FW: Planning consultation - FG/15/25/PL Kivesborough Littlehampton Road Ferring BN12 6PN

West Sussex Fire & Rescue – additional attachment to response

Having viewed the details for planning application No. FG/15/25/PL for the subdivision of existing curtilage and erection of 3 No. 3-bedroom dwellings (self-build), retention of existing access and provision of landscaping (resubmission following FG/49/24/PL). This application affects a Public Right of Way and is in CIL Zone 4. Further information is required for the access to this site, to ensure it complies with the requirements of Approved Document B (AD-B) Volume 1 B5 Section 13.

Figure 3- Proposed Site Plan

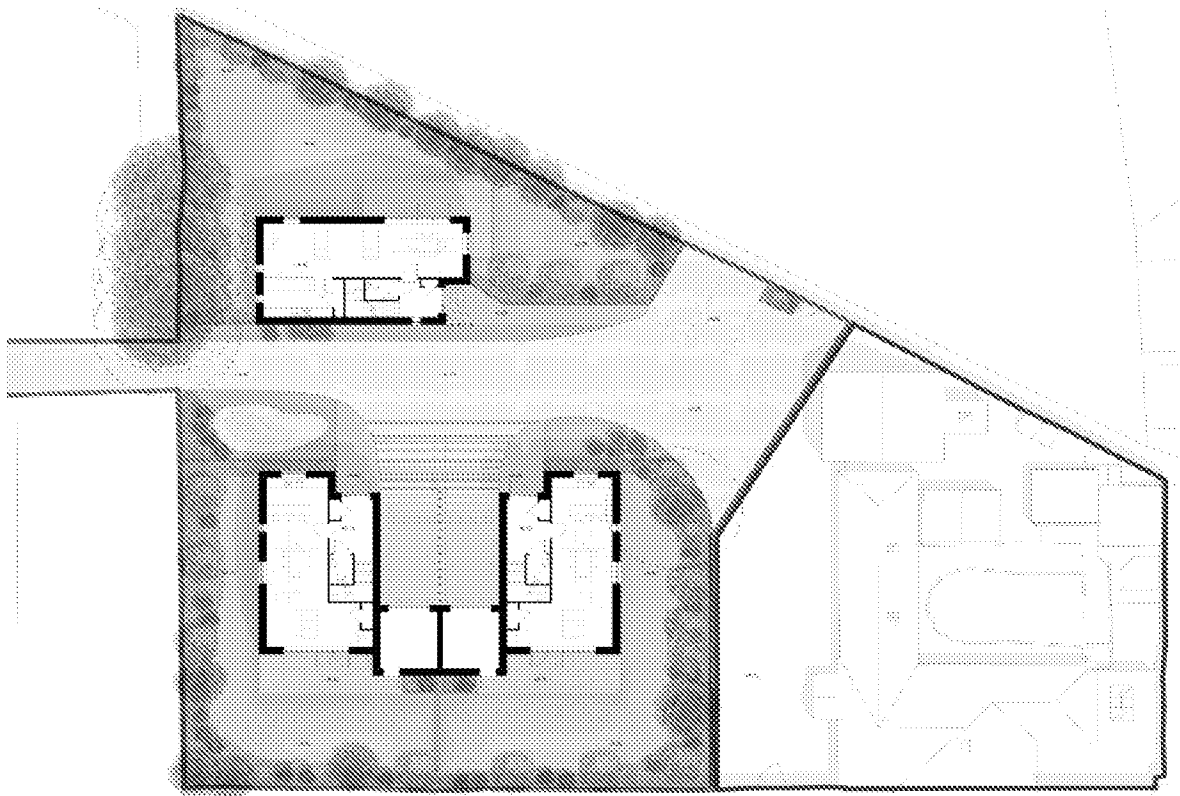
Currently the nearest fire hydrant the new build dwellings is 220m away at the entrance to Ferring Nursery, which is 55m further than the 175m distance required for a domestic property.

There is another fire hydrant closer, but it is unclear if there is suitable access to it from these properties, so this will need to be clarified, I have added a screen shot to show its location. If there is not suitable access the applicant will need to identify how they intend providing water for firefighting to comply with AD-B Volume 1 B5 section 15.
